# JENISHAY FARMS Pre-Development Grading & Erosion Control Plan El Paso County, Colorado

Prepared By:  
**Lodestar Engineering, LLC  
P.O. Box 88461  
Colorado Springs, CO 80908  
January, 2021**

EL PASO COUNTY PRE-DEVELOPMENT  
 REPLAT TERRA RIDGE LOTS 5 & 6 W/ 7 LOTS IN  
 JENISHAY FARMS  
**SITE GRADING & EROSION  
 CONTROL PLAN**

RURAL LOCAL – PAVED  
TYPICAL SECTION  
SCALE N.T.S.

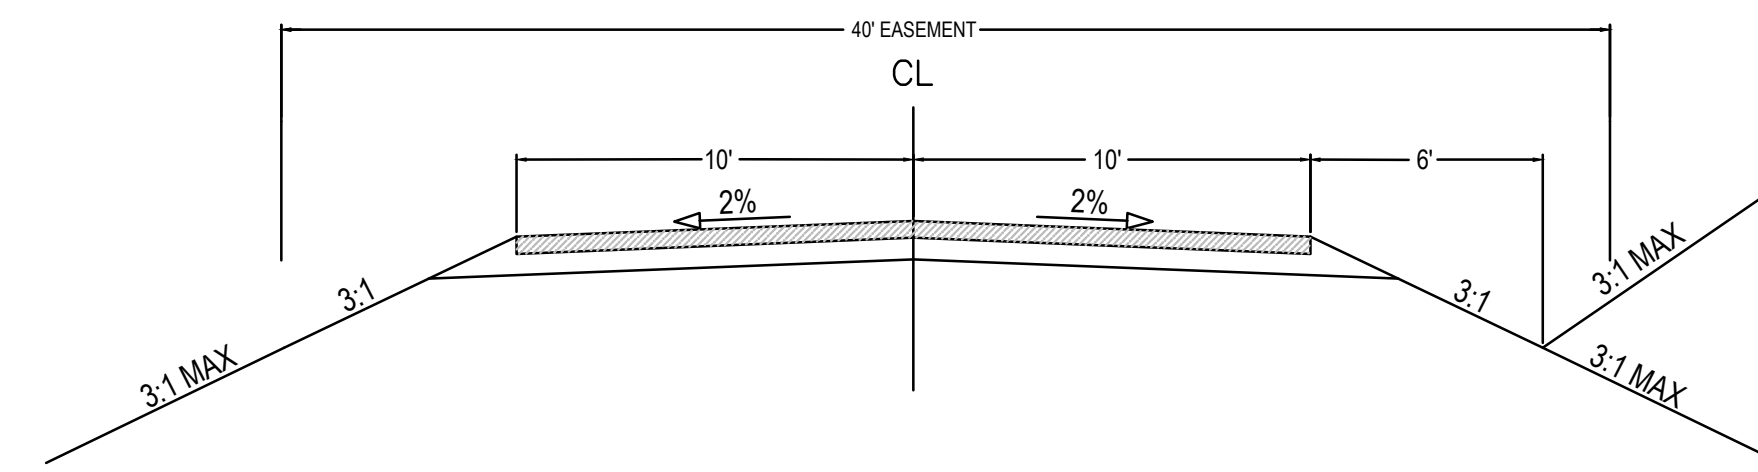
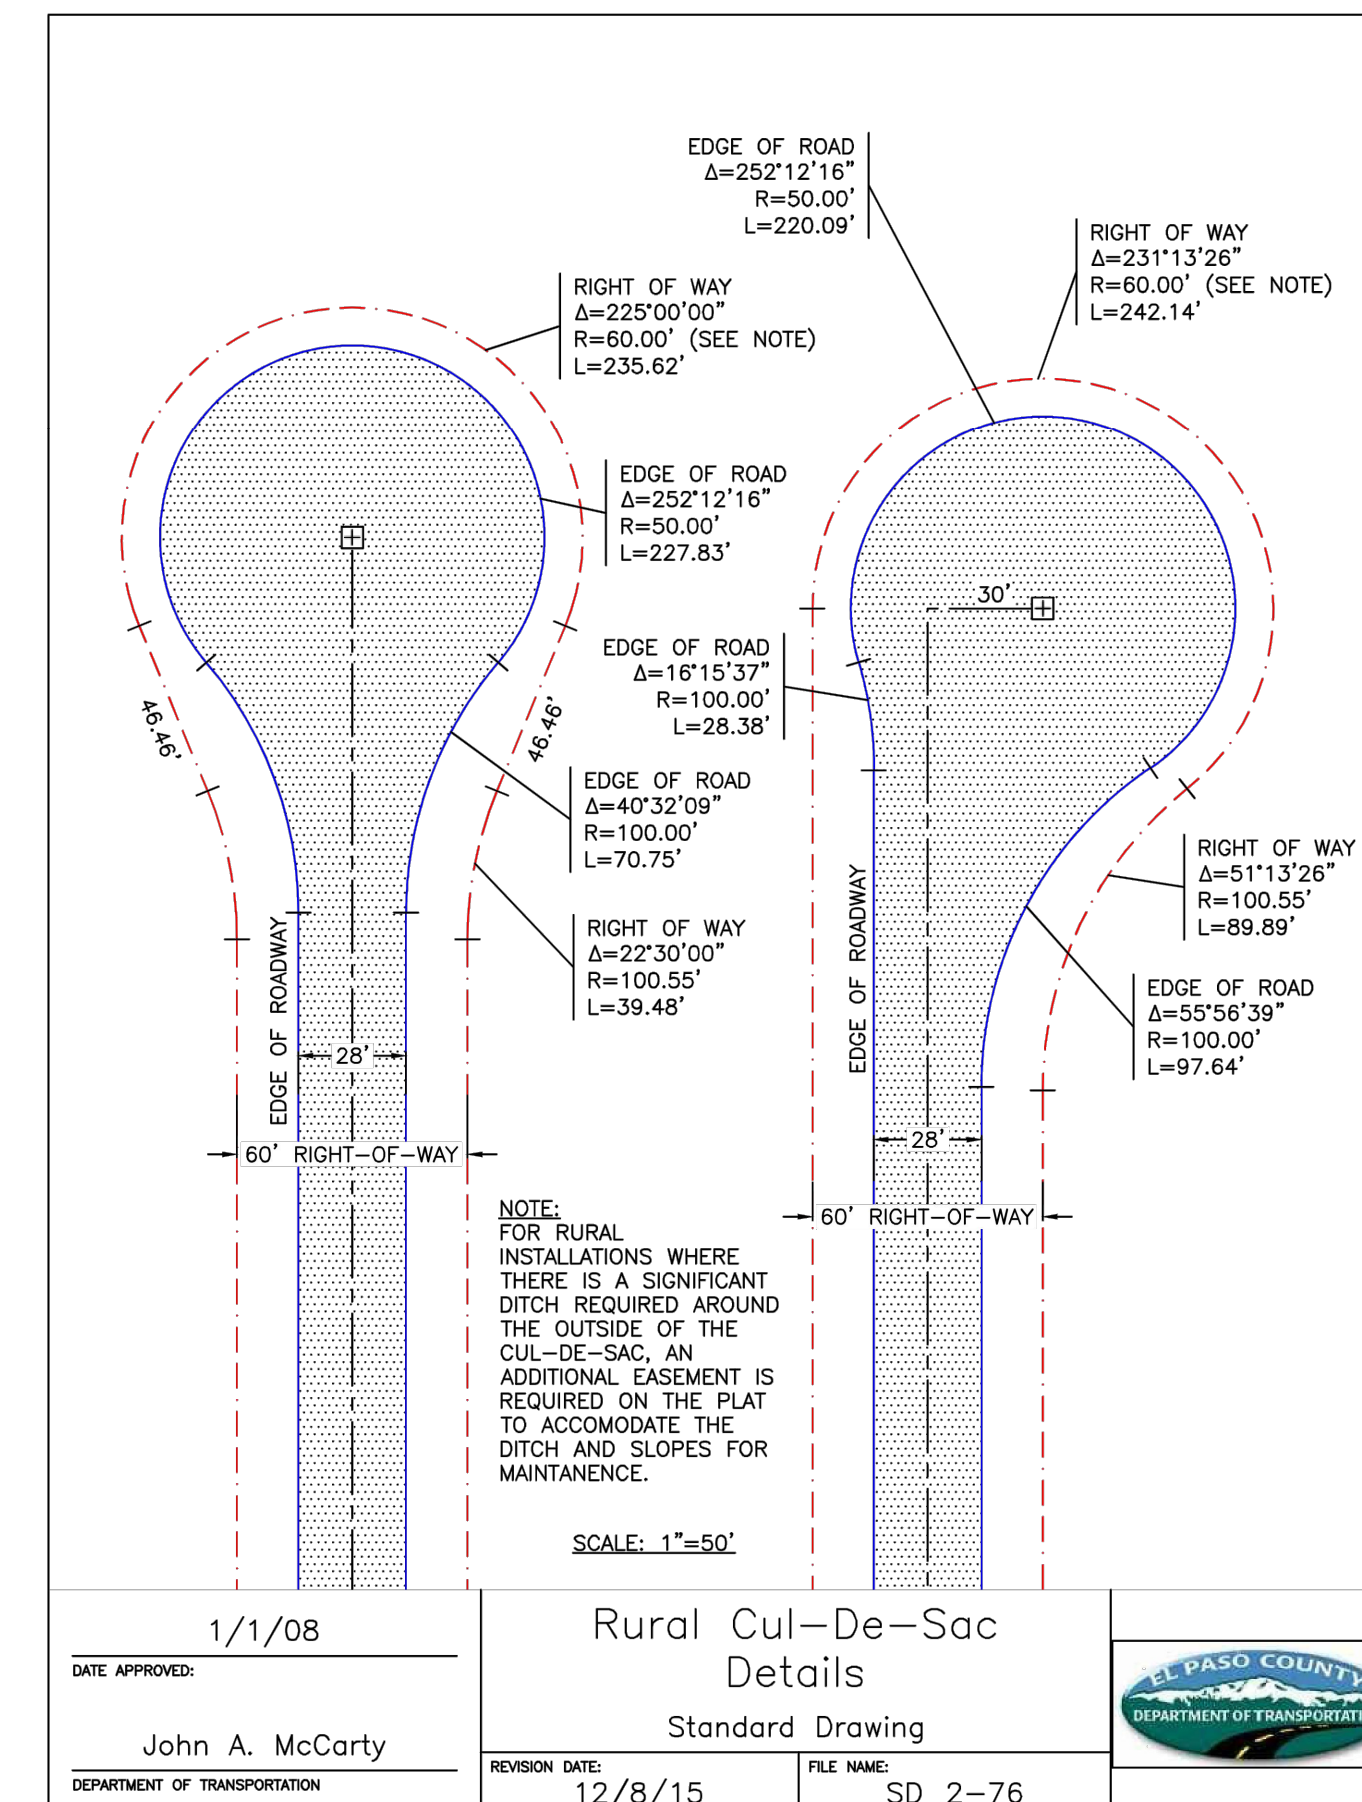
NOTE: SUBGRADE UNDERCUT GRADING ONLY IS PERMITTED WITH THIS PREDEVELOPMENT CONSTRUCTION PLAN. ASPHALT AND AGGREGATE BASE COARSE SHALL NOT BE CONSTRUCTED WITH THE PREDEVELOPMENT GRADING.

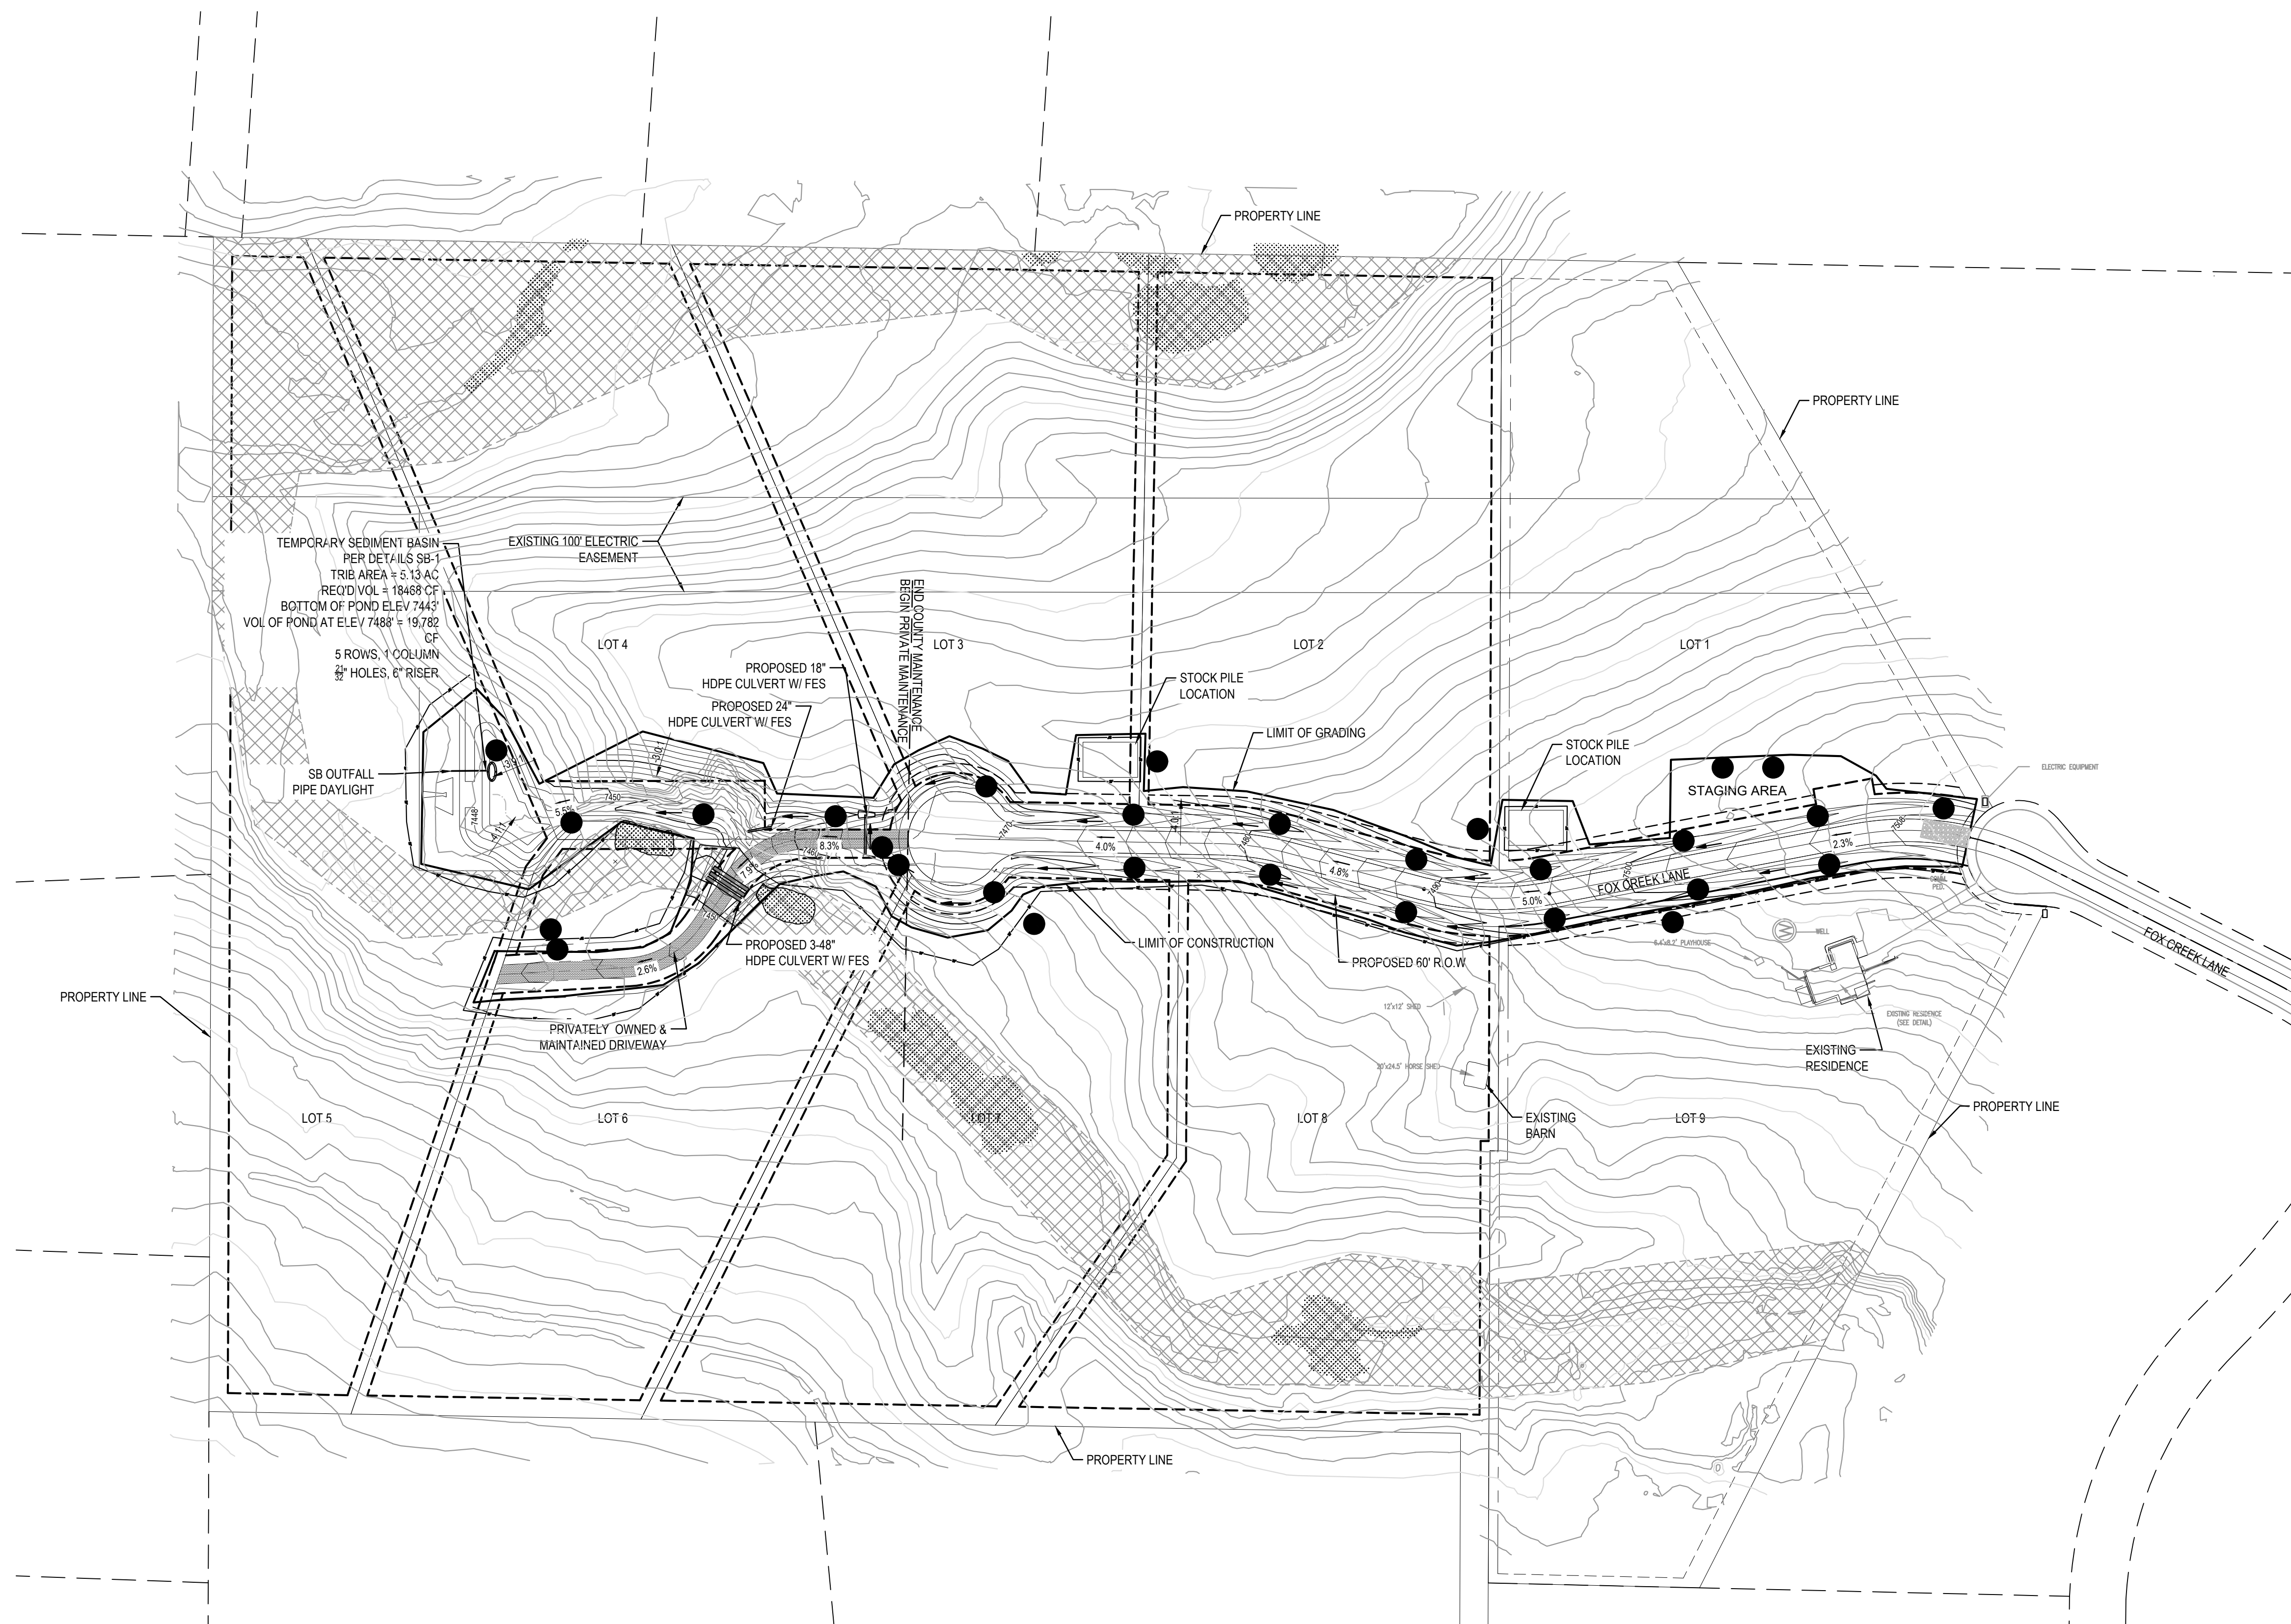
Unresolved comment from Review #2: bring text to front.

Unresolved comment from Review #2: There needs to be a stabilized/armored flow path from outfall to creek that protects land between and creek bank from erosion.

Remove the private driveway and culverts from the pre-development grading or identify as not a part of the approved pre-development grading plan.  
 Unresolved. The culverts will not be installed with the early grading. Hydraulic analysis, design, and approval of construction plans for this channel crossing will be approved with the final plat application.

add these hatching types to Legend.

Unresolved comment from Review #1 and #2:  
 - Show location waste container, and/or office trailers, or notate locations are TBD by contractor.  
 - Notate condition and type of existing vegetation.

Unresolved comment from Review #2:  
 Show contour labels on major contours.  
 And show some drainage flow arrows outside of the limits of construction, within the property so the overall site drainage can be seen at a glance. Similar to what is shown on the 2nd to last page of the drainage report.

Identify a temporary swale from the southern roadside ditch to the temporary sediment pond.  
 Unresolved

Unresolved comment from Review #2:  
 Clarify what is meant by "this area," since no note reference is seen on the plans. Do you mean the stockpile locations?

Unresolved comment from Review #1 and #2:  
 VTC must be min 75ft length per EPC detail. As shown it is only 50ft long.

Unresolved comment from Review #1:  
 Since silt fence is placed on slope, need to show j-hooks as necessary to slow down concentrated flow along SF and excessive ponding accumulating at low points.  
 Per installation note #6 on detail on sheet below.  
 Review #2 clarification: best to show/notate location of j-hooks so contractor knows where to install them.

show more flow arrows throughout site (ie: within lots so overall drainage is more clear)

Unresolved comment from Review #1 and #2:  
 If the same as the limits of disturbance, change to "construction boundary/limits of disturbance" or add "limits of disturbance" to the legend and figure
